OXFORDSHIRE COUNTY COUNCIL'S RESPONSE TO CONSULTATION ON THE FOLLOWING DEVELOPMENT PROPOSAL

Application no: 21/03177/F

Proposal: Full planning application for employment development (Use Classes E(g)(iii), B2 and/or B8) and associated parking and servicing, landscaping and associated works

Location: Axis J9 Phase 3 Howes Lane Bicester

PHASE 3 External Works & Levels

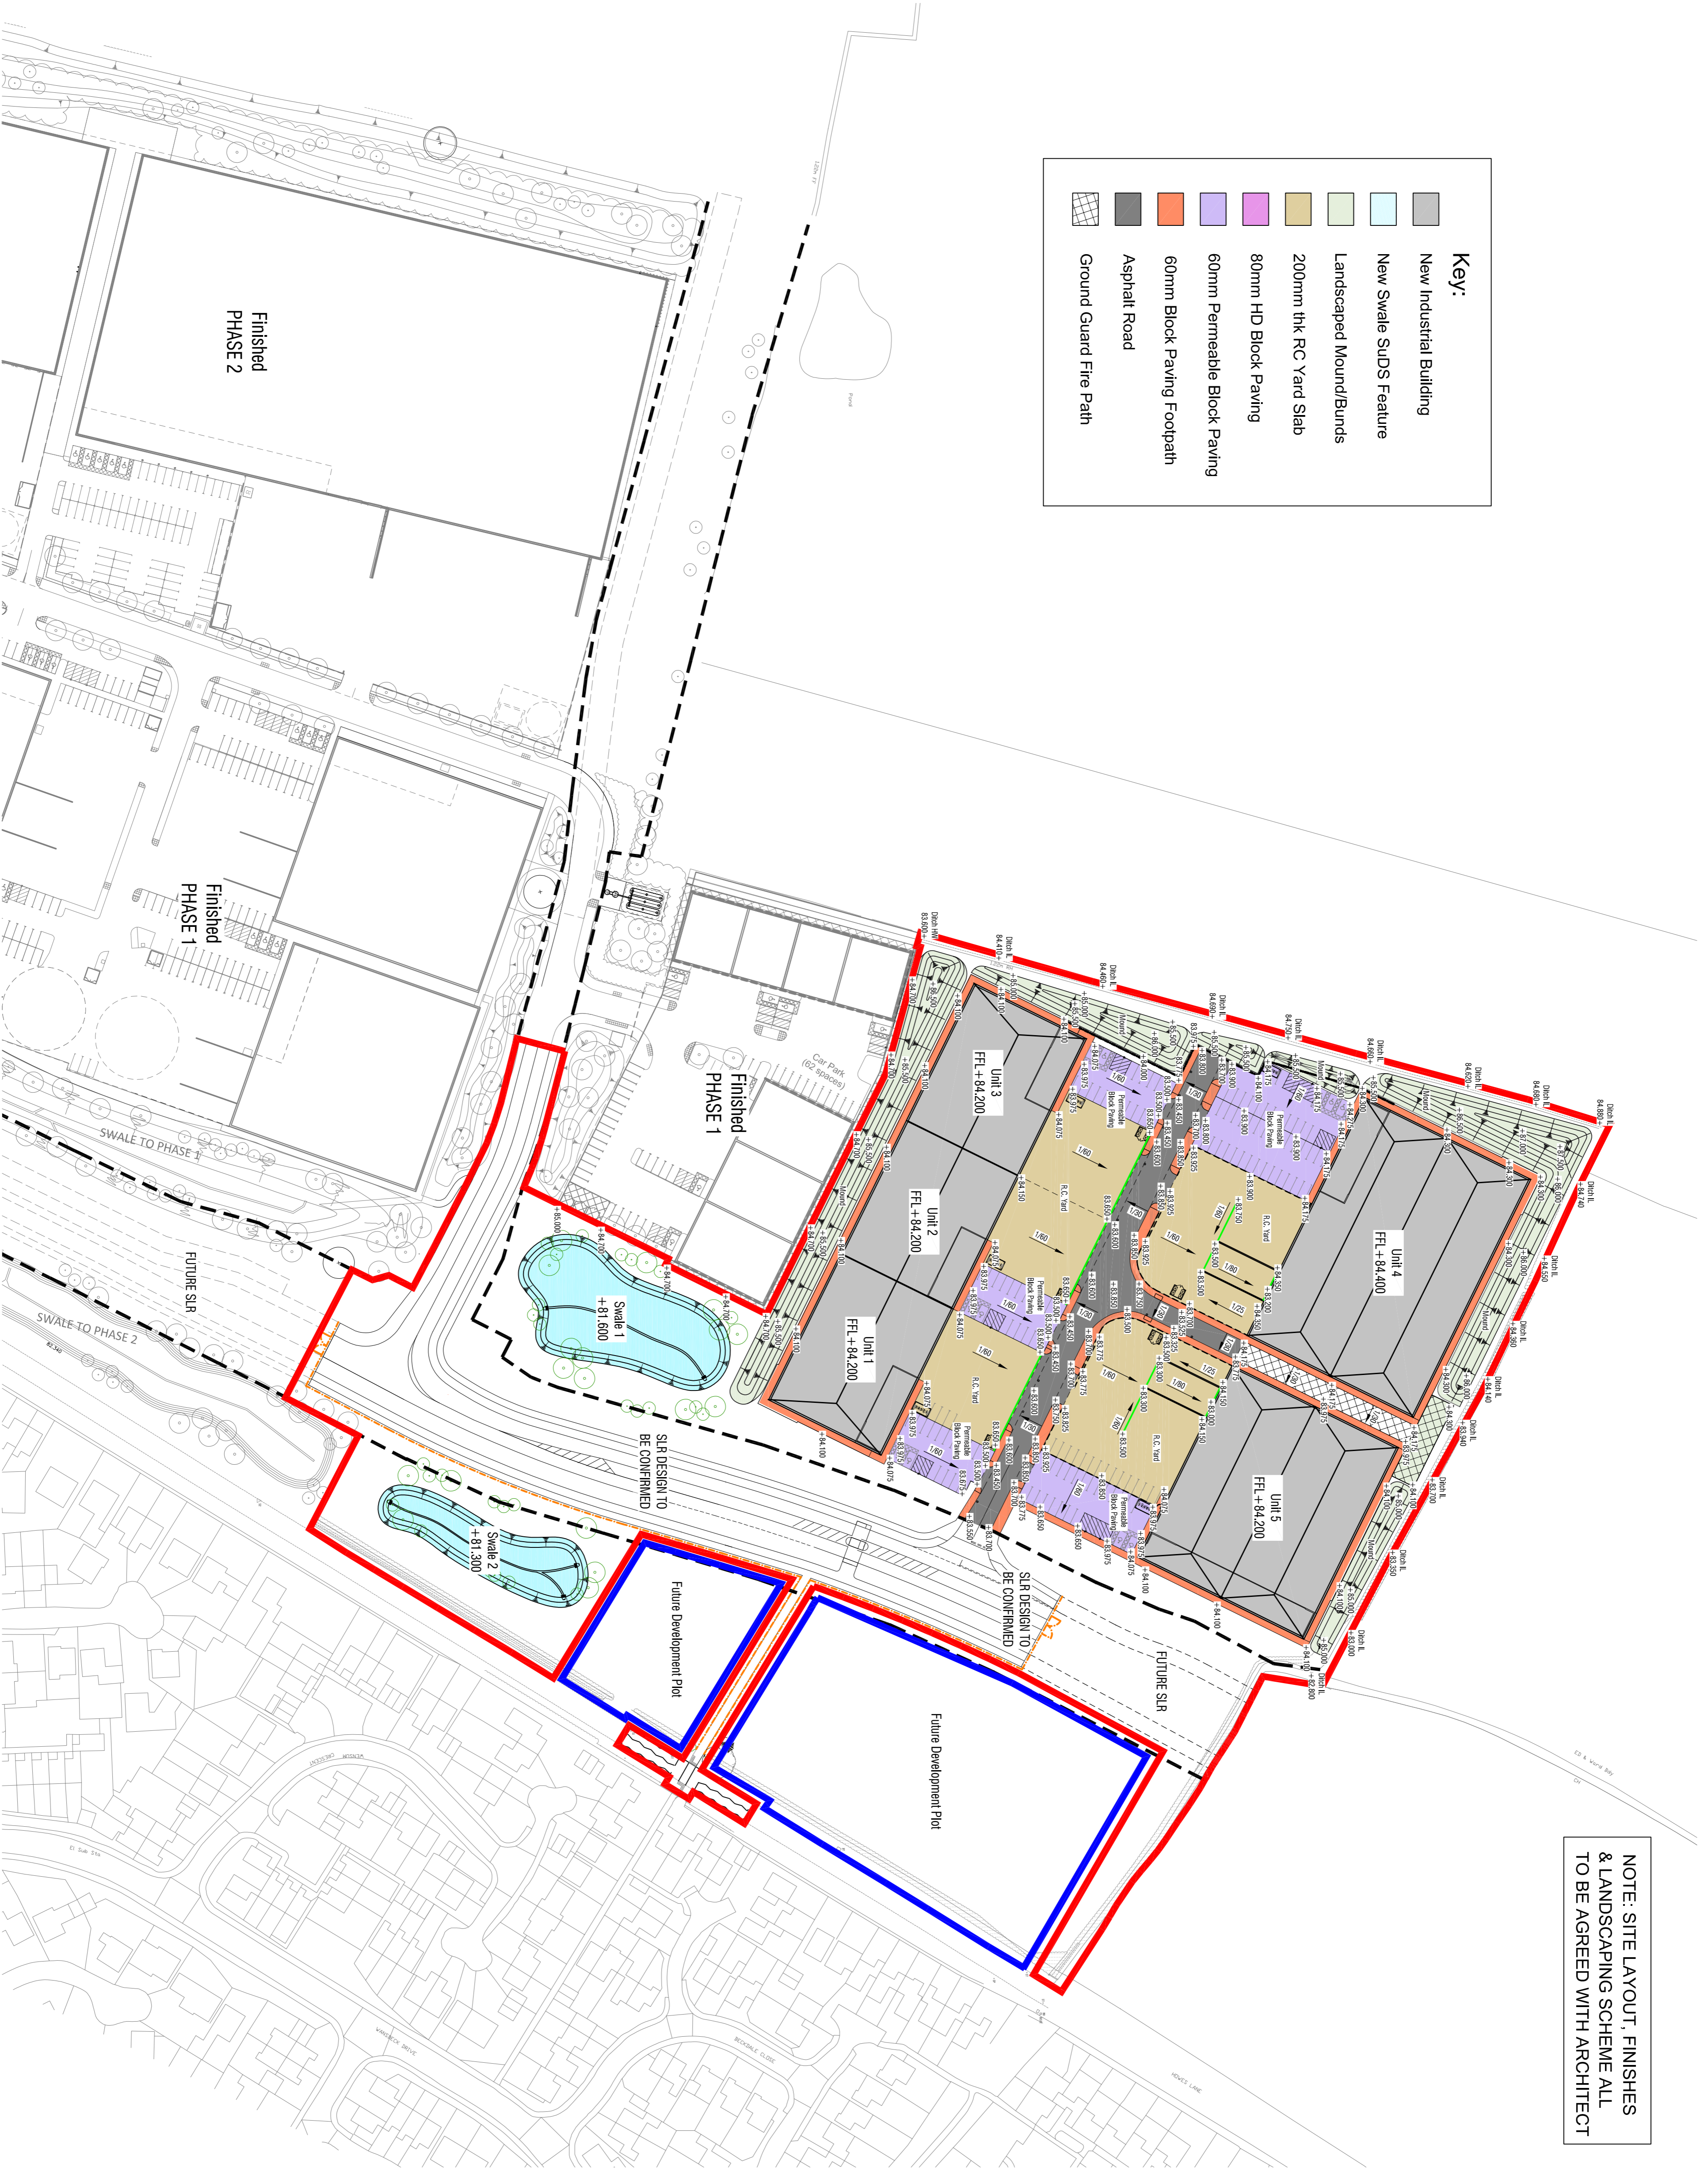
Surface water catchment plan does not show the extent of the areas clearly. Please make use of different colours and hatch the areas solid, clearly stating the area and also the area with urban creep.

Basin cover levels are not provided on the plan drawings, please provide cover levels of storage structures and the volumes.

The future SL area is not covered in the phase 3 drainage strategy however its shown within the phase 3 development. Clarification on the drainage strategy is required.

Plan drawing shows headwall discharging to an green hatched area. This has not been denoted on the key. The outfall location should be clearly shown on the drawing and where it leads to exactly.

Parking spaces opposite units 6-8,9-10 and 11 does not have permeable paving. Clarification required on how the surface water in this area will be treated.

Permeable paving is proposed however this has not been keyed up on the drainage strategy drawing. Also provide storage volumes and invert level of the sub base on the drainage plans. All SuDs features and drainage infrastructure should be keyed up correctly on drainage plans.
